Application Ref:	3/2026/0045			 Ribble Valley Borough Council www.ribblevalley.gov.uk				
Date Inspected:	10/02/26	Site Notice:	N/A					
Officer:	LW							
DELEGATED ITEM FILE REPORT:					APPROVAL

Development Description:	Proposed alterations to front boundary retaining wall including repointing, increase in height, new copings, steel railings along the top of wall and removal of existing hedge.
Site Address/Location:	70 Mellor Brow, Mellor, BB2 7EX.

**Elevation from Roadway - Proposed**

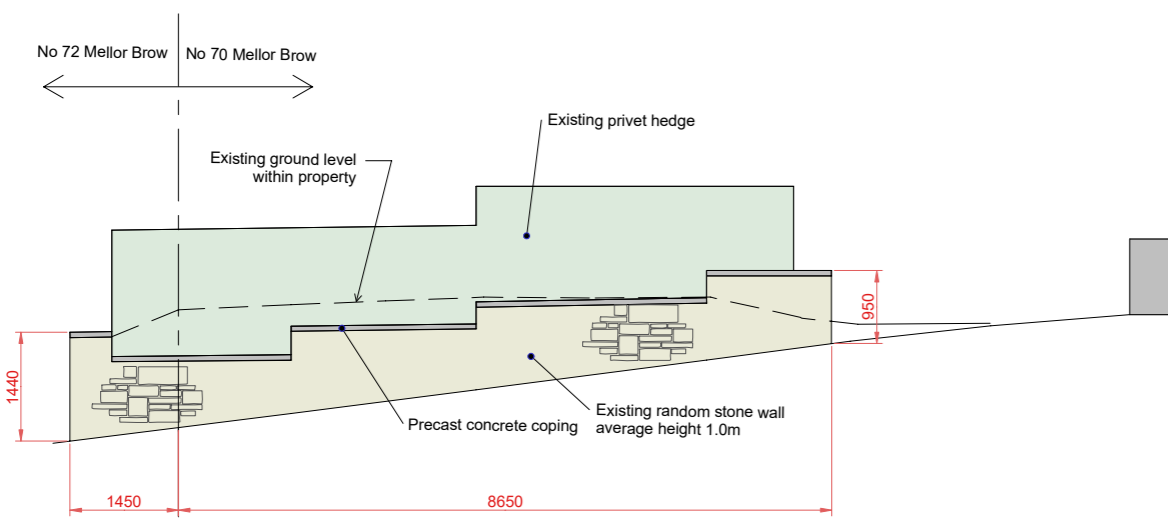
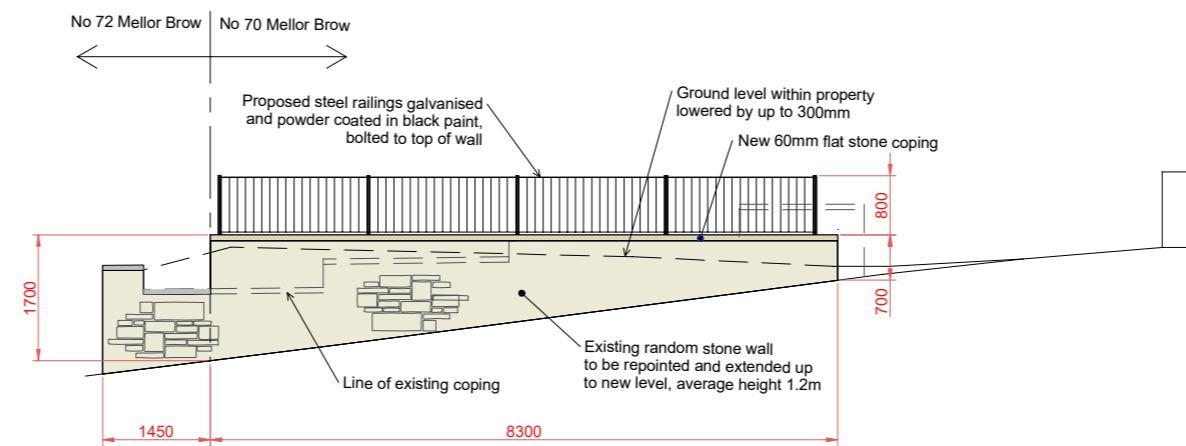
The proposal would be readily visible from Mellor Brow and would therefore have a clear visual impact. However, the proposal comprises a relatively modest alteration to the existing stone boundary wall and installation of black 0.8m high steel railings above. Whilst it is noted that steel railings are not a well-established boundary treatment within the immediate area, it is not considered, on balance, that their installation would result in any significant detrimental harm upon the existing visual amenities of the surrounding area that would warrant the refusal to grant planning permission in this particular instance.

However, concerns were raised over increasing the height of the wall which includes a section which sits 1.7m above the carriageway level. The LHA therefore requested that the wall be reduced to no more than 1m in height or a visibility splay drawing submitted, set back 2.4 metres from the centre of the access and extended 43 metres along the nearside carriageway edge.

Applicant has confirmed that the proposal does not relate to the creation of a new wall, but the repair/partial rebuild of an existing wall. The height of the wall prior to demolition was 0.95m, above which was a tall dense hedge which afforded no visibility. It is proposed to reduce this height to 0.7m which would allow improved visibility. The wall will then continue at this lower height for the first half of its length, with the proposed increase in height only impacting the second half its length in order to create a level base for the proposed railings.

Following this, an updated consultation response was received from the LHA dated 27th March 2026 confirming that they do not raise an objection to the proposal. It is noted that whilst the proposal does not make a significant impact to the current visibility constraints, the LHA acknowledges that the removal of the vegetation which currently sits over the boundary wall will assist in improving visibility. As such, they do not consider that the proposed development would have a significant impact on highway safety or capacity in the immediate vicinity of the site.
